MEMORANDUM

DATE: March 3, 2023
TO: Shane Whitney, Civil Plan Review
FROM: Emily Morgan, Senior Planner
RE: Sunnyside Village Cohousing – *Civil Review 1* - (PA22-042; G23-0004)
CC: Chris Holland, Planning Manager
Ken McIntyre, PE, Assistant City Engineer

A000

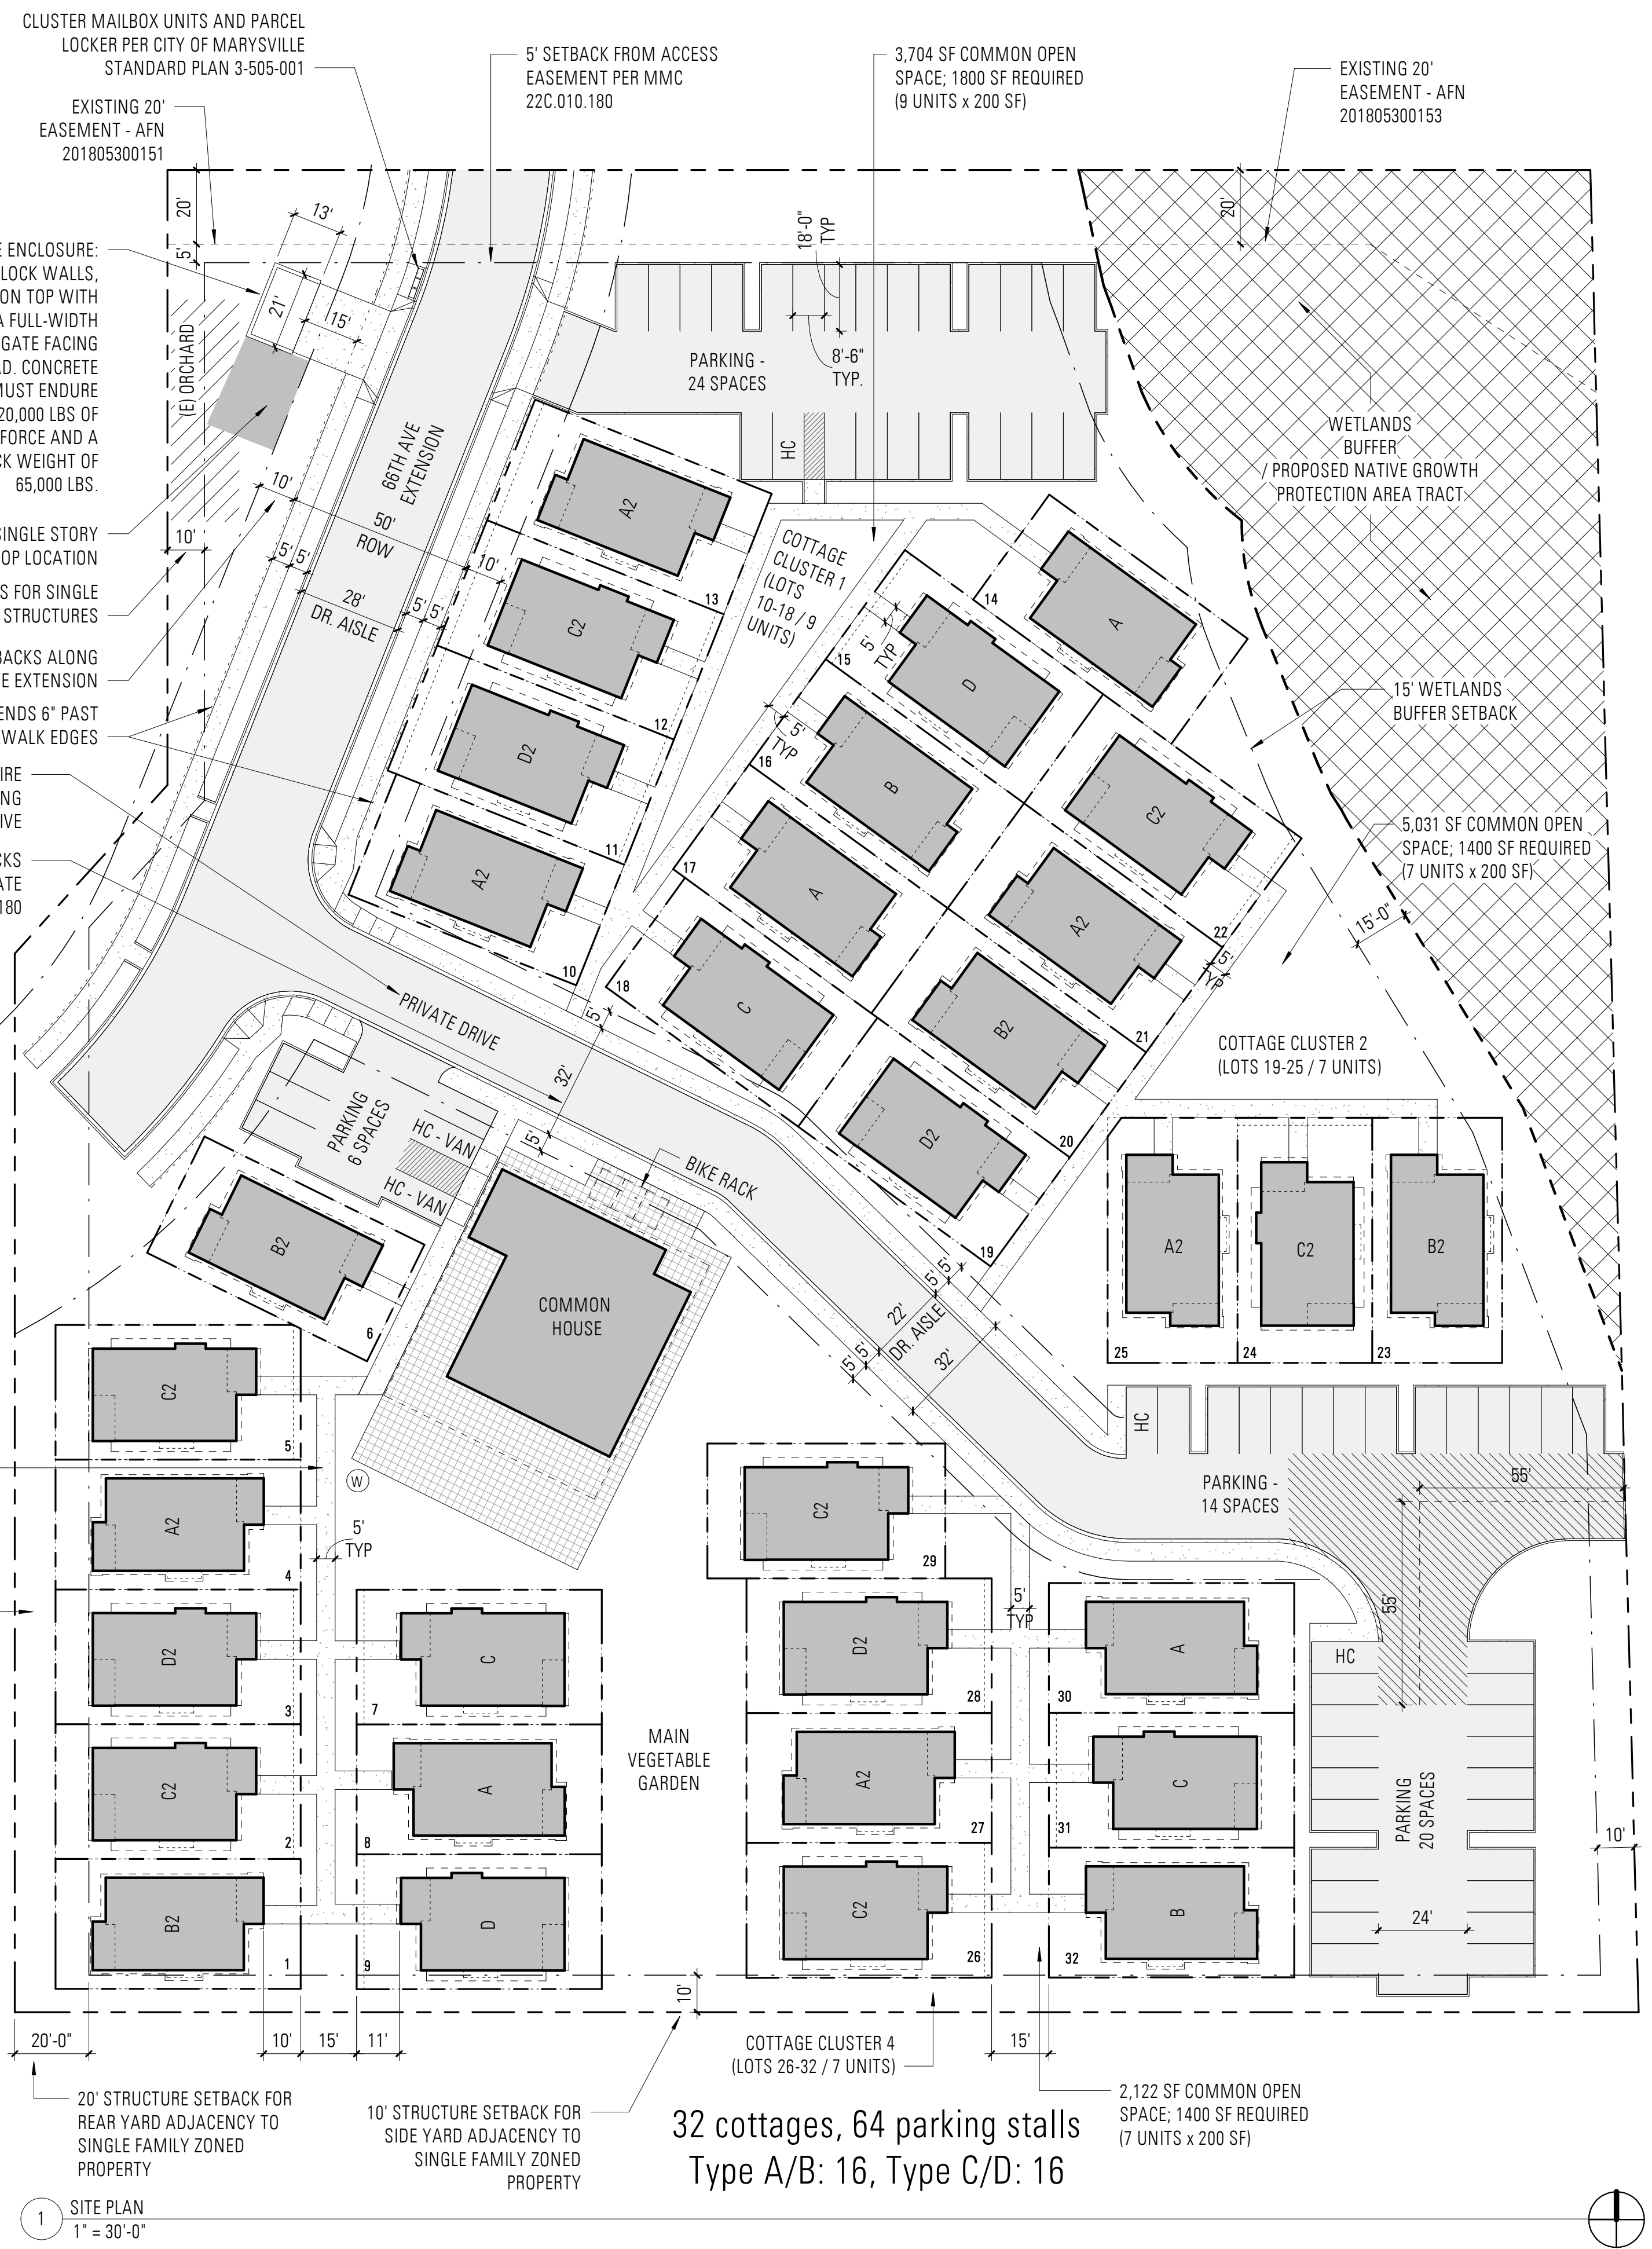
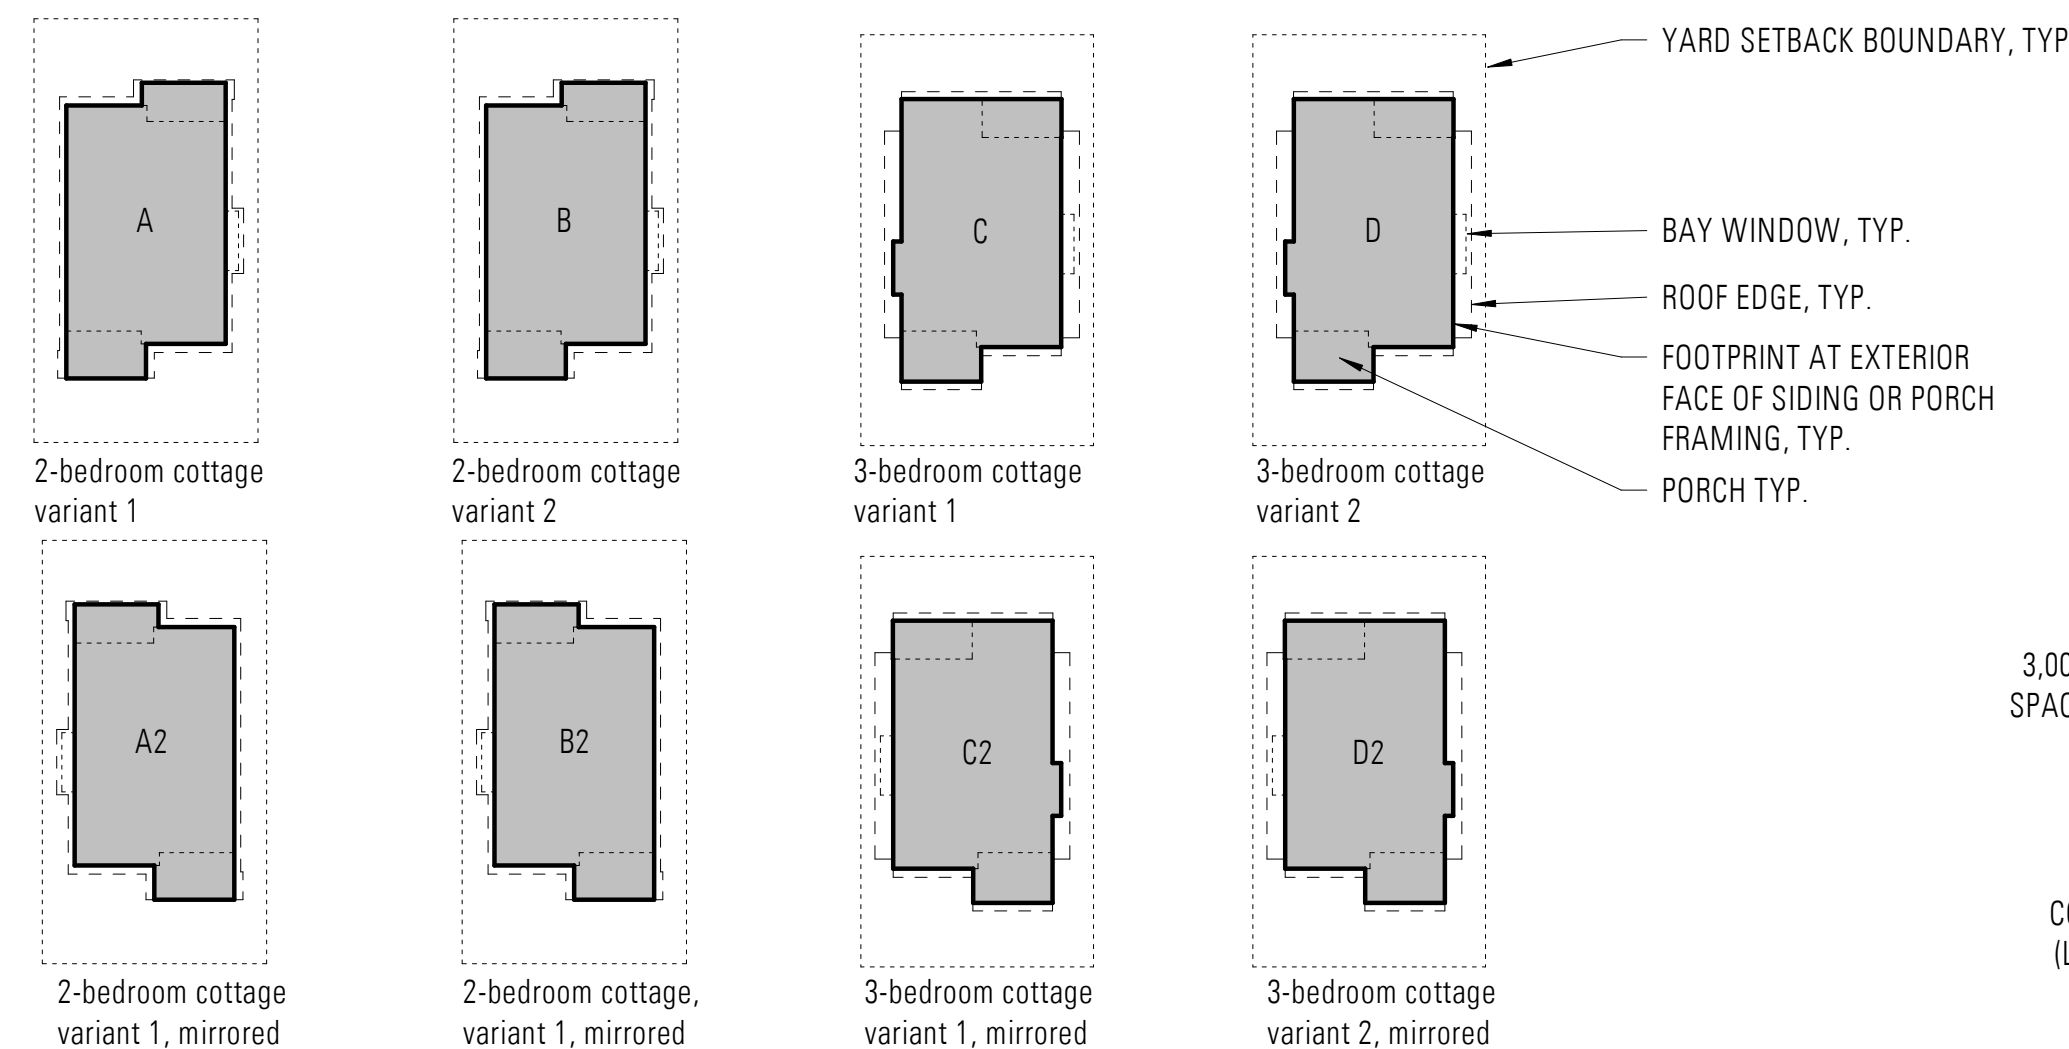
- 9. Parking areas are required to be planted with Type L4 landscaping. Confirm the proposed parking area landscaping meets the L4 landscaping standards of MMC 22C.120.110(4)
- 10. Provide details and specs that demonstrate the required trash and recycling enclosure meets the required standards of MMC 22C.010.280(12)(c) and MMC 22C.120.160.
- 11. Provide details that includes the typical design specifics for pedestrian amenities (i.e. benches, picnic tables, planters), if applicable.
- 12. Per MMC 22C.120.040, *all landscaped areas shall be provided with an irrigation system or a readily available water supply with at least one outlet located within 50 feet of all plant material.* Provide an irrigation plan that demonstrates compliance with this provision.
